11 October 2019

Our ref: SYDEN233503-IA02

Interim Audit Advice 02: Opinion on Capping Depth for Management of Asbestos in Soil for Development at Parramatta West Public School

Appendix A: Schematic Capping Specifications

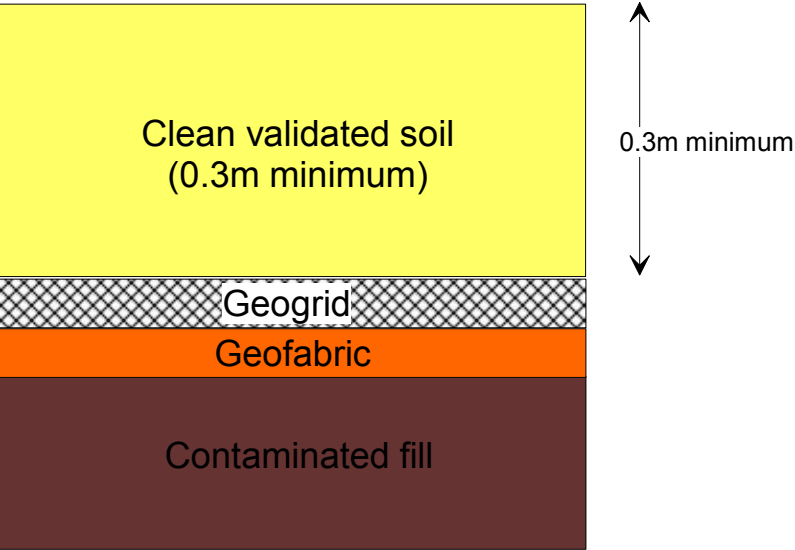
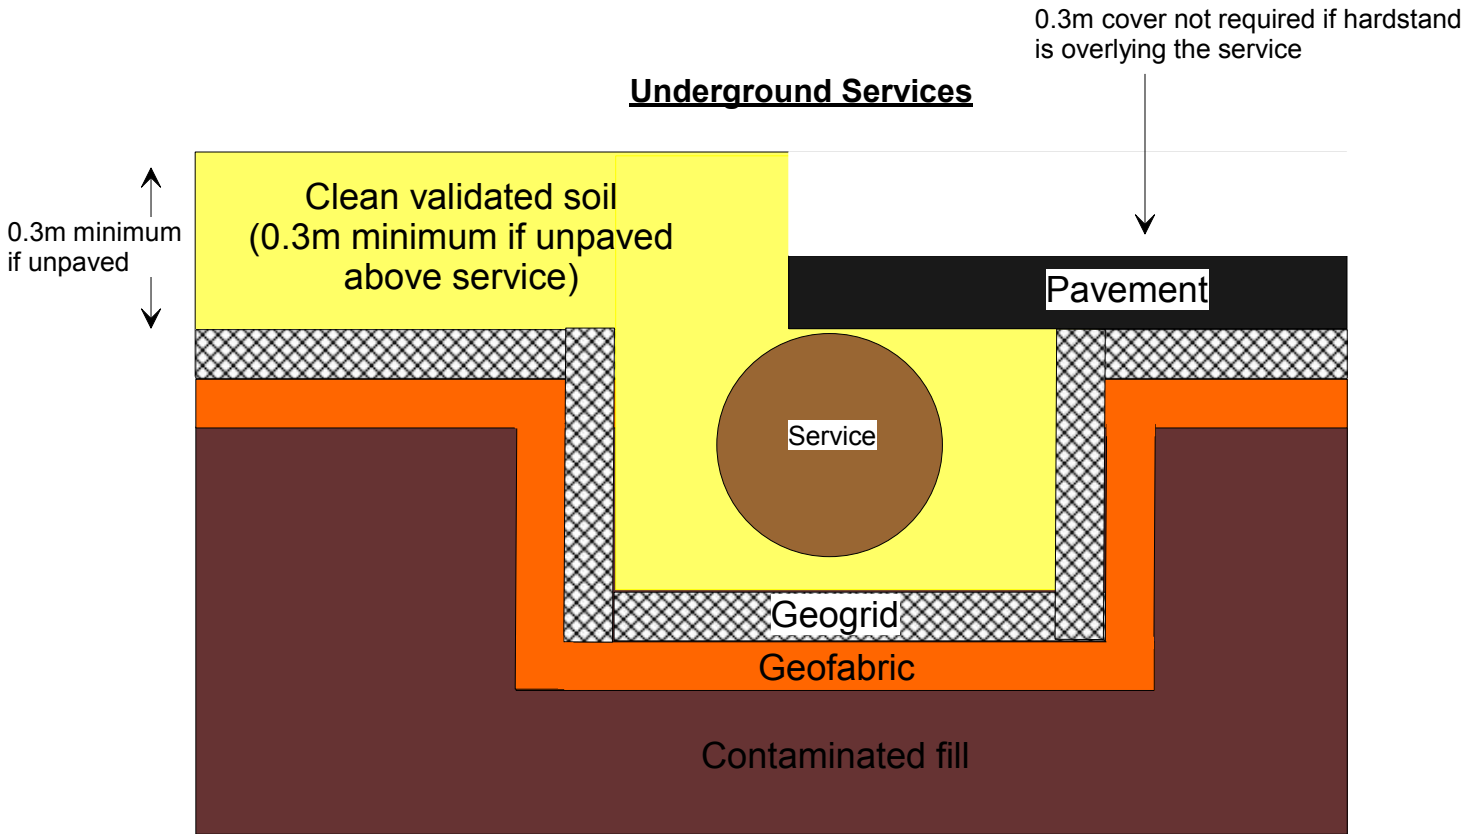
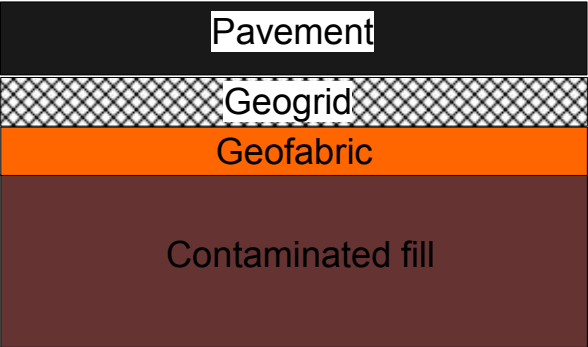
Item	EPA Comments	School Infrastructure Response
2q	EIS Appendix CC 'Remediation Action Plan' proposes capping and containment of asbestos contaminated soils with a 300 millimetres cap of clean fill over the marker layer. However, the Western Australian DoH ' <i>Guidelines for the Assessment and Management of Asbestos – Contaminated Sites in Western Australia – May 2009</i> ' recommends the depth of the clean fill should be at least 1m for public open spaces and at least 0.5m for all other uses, such as residential or commercial activities.	Western Australian (WA) DoH 2009 Guidelines indicates that the implementation of additional measures at such as marker layers, on-going management plans, and appropriate notification and enforcement mechanisms can be used to support a proposal for reduced capping thickness. The potential for generating respirable, airborne asbestos fibres from soils containing bonded Asbestos Containing Material (ACM) is low, even during soil disturbance (this was supported during the DSI - see Section 8.3 of the report). Notwithstanding this and based on the EPA's comments, the Department of Education will engage an EPA Accredited Site Auditor who shall undertake an assessment of the proposed depth of capping over contaminated fill on the north site. The Department of Education commits to adopting the recommendations of the Auditor in that regard. A copy of the Auditor's Report is to be provided to the Department of Planning, Industry and Environment when available (refer to Section 1.2 above for more detail).

2r	The EPA considers the emplacement of only 300 millimetres of clean fill material over the marker layer and no cap under hardstand areas poses a potential risk to future users.

Given that the discussion above indicates low level of human health risk for a site with sensitive receptors, I consider that additional capping of the site is not warranted.

For clarity, I recommend:

- No placement of additional fill material or marker layer, and
- Review of the School's current Asbestos Management Plan to ensure regular (at least annual) site inspections by a person competent to identify Bonded ACM in surface soil with removal of any visible Bonded ACM fragments is included as a risk management measure.
